Project No.: The Tanglewood-Mirror
DATE: JUNE 15, 2020
DRAWN BY: Steven Madden
DESIGNED BY: Steven Madden
REVISED:

Sheet Title
FRONT & REAR ELEVATIONS

BUILDER	Camberland Homes, Inc.	CITY / CO	Johnston Co. / Johnston
JOB NAME	Holland Residence	ADDRESS	Site Address
PLAN	Holland Residence	MODEL	Roof
SEAL DATE	Seal Date	DATE REV.	03/01/22
QUOTE #	J0225-1061	DRAWN BY	David Landry
JOB #		SALES REP	Larry Norris

RIGHT SIDE ELEVATION
SCALE: 1/4" = 1'-0"

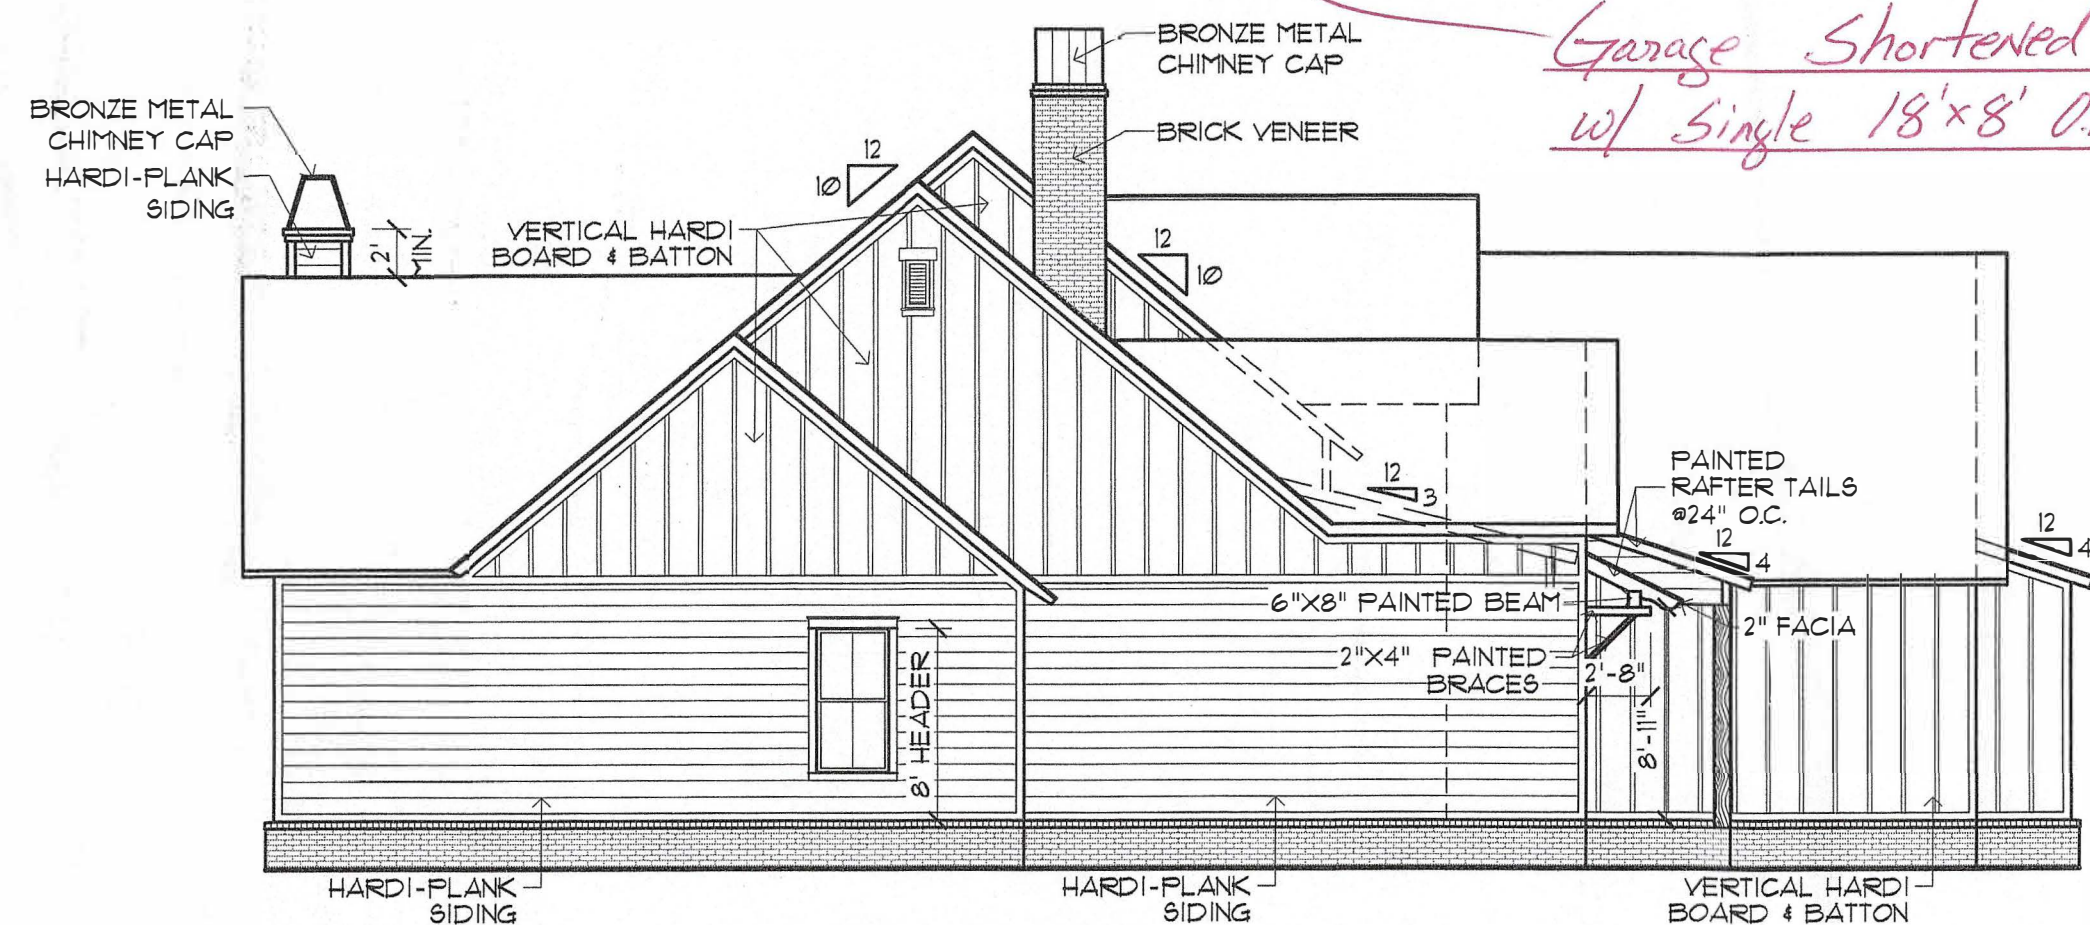
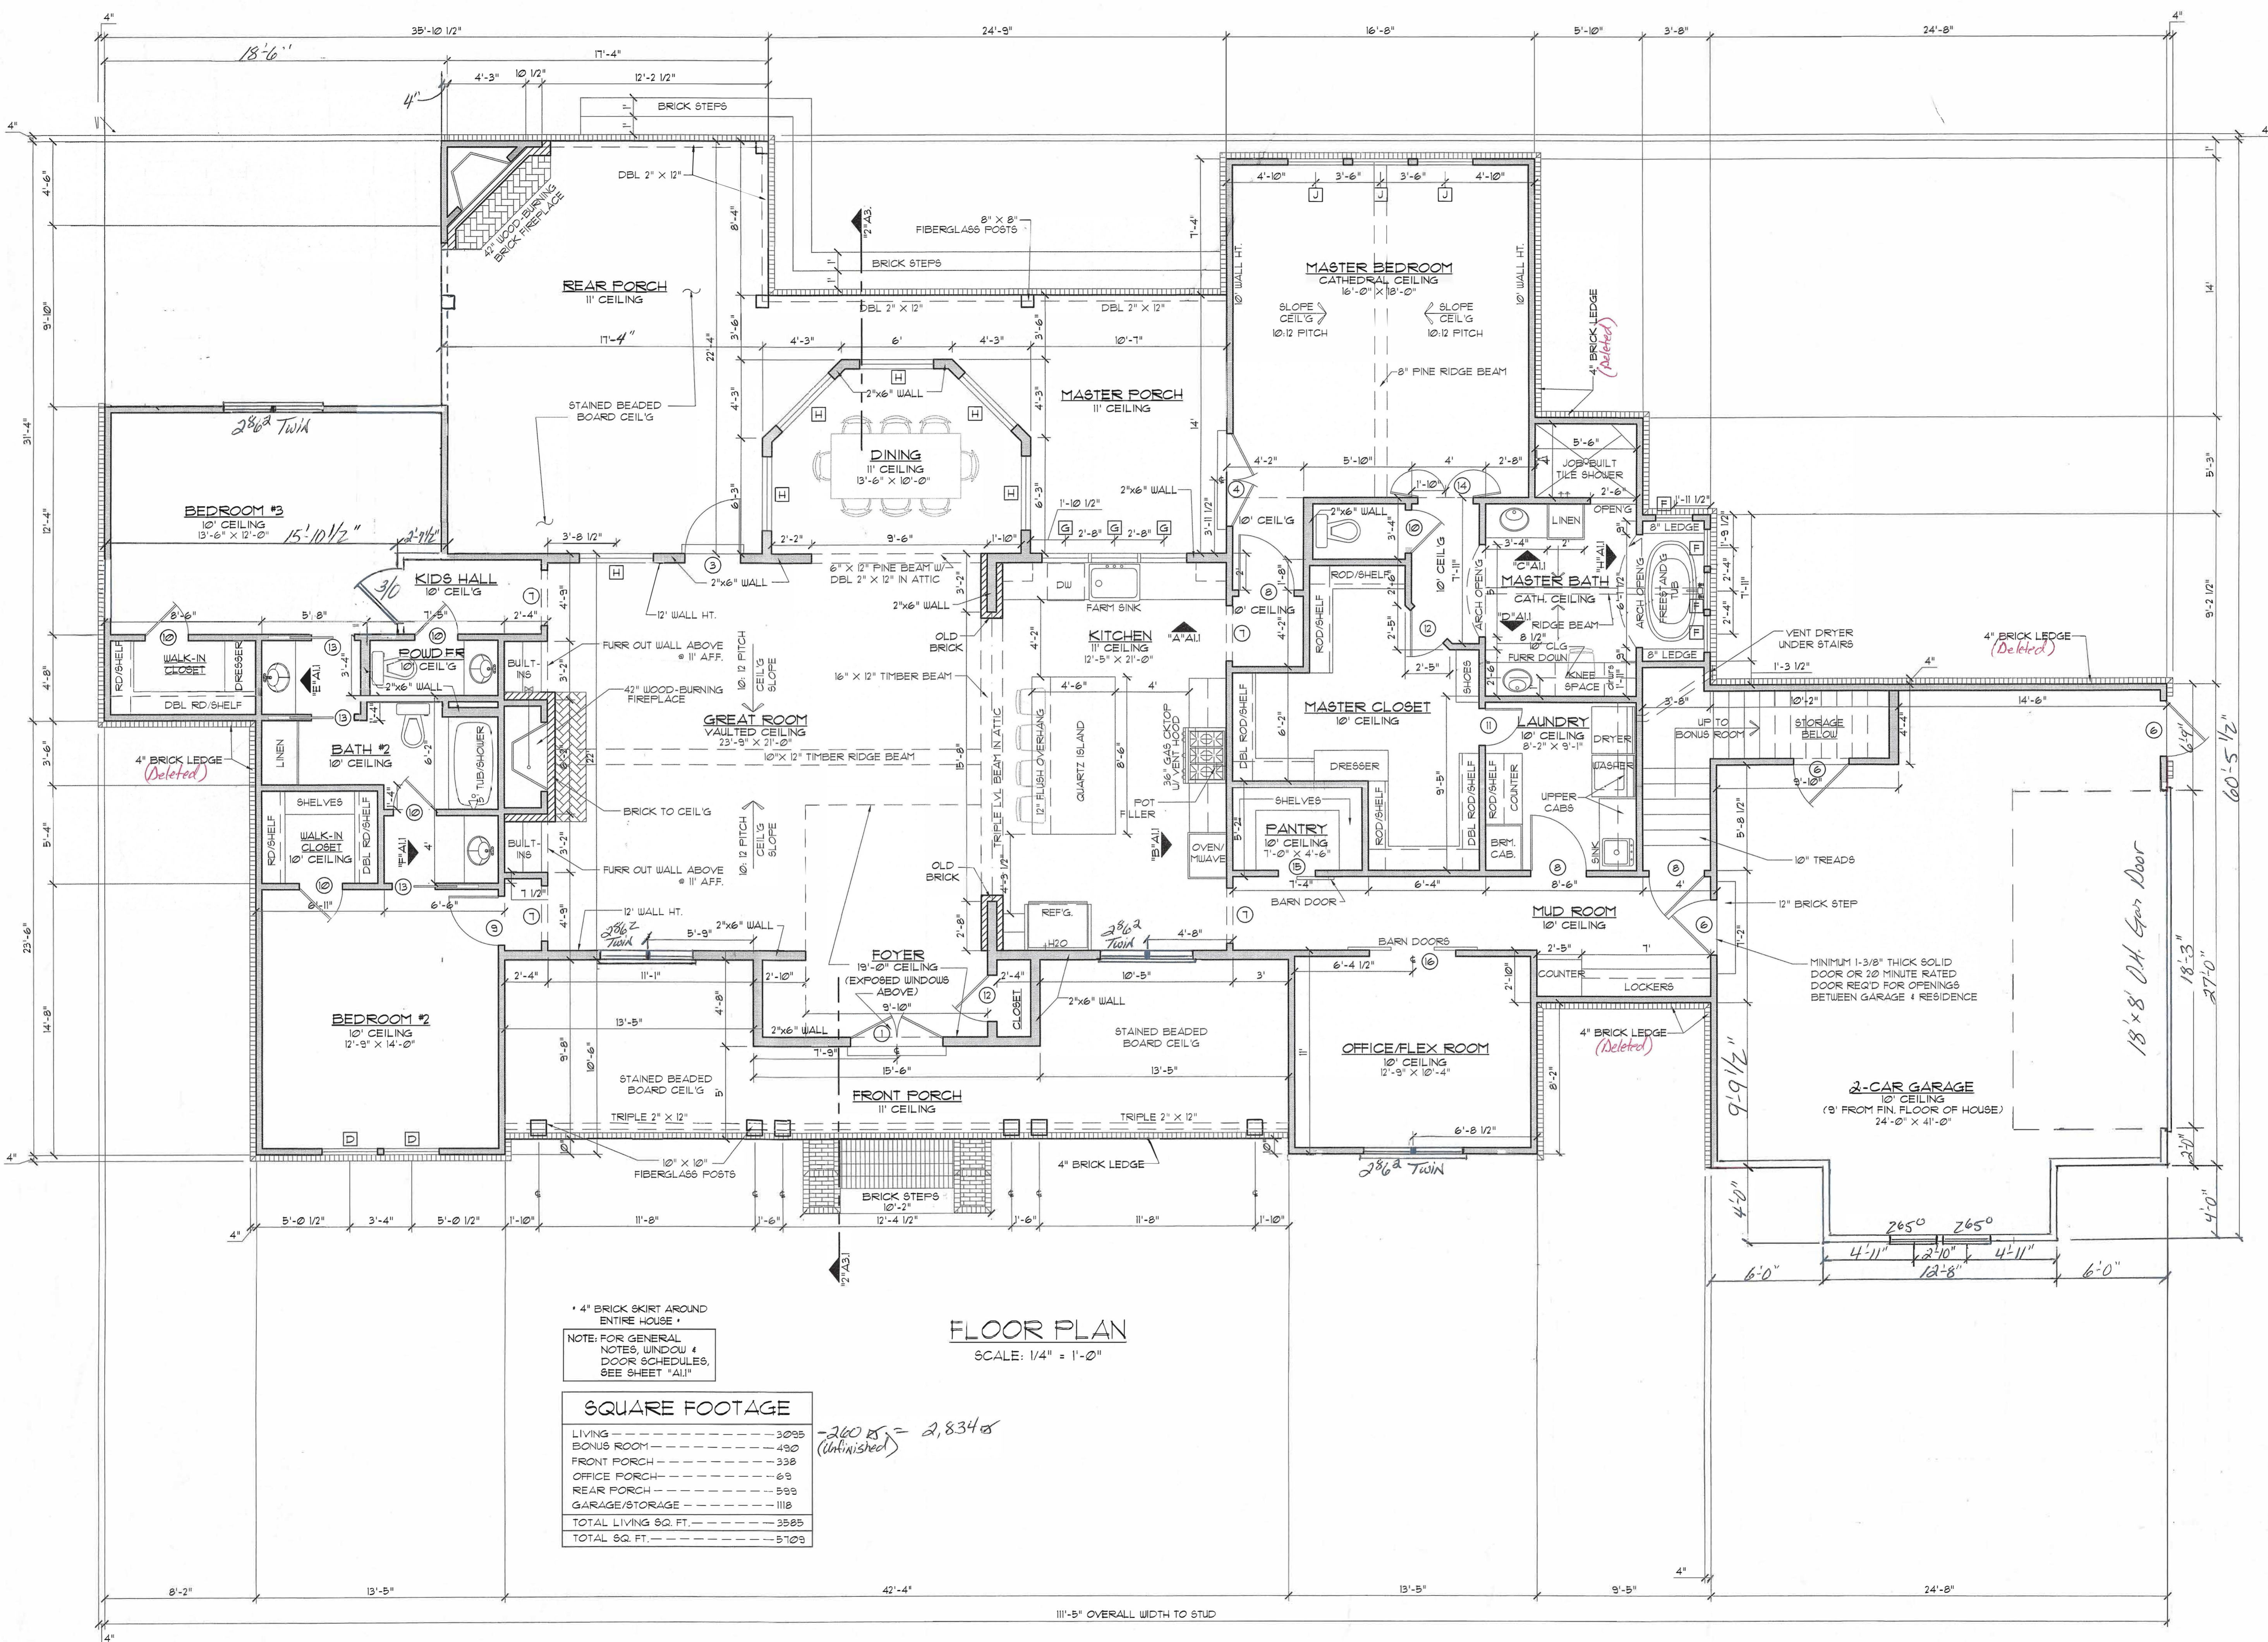
Garage Shortened to 26' w/ Single 18'x8' O.H. Gar Door
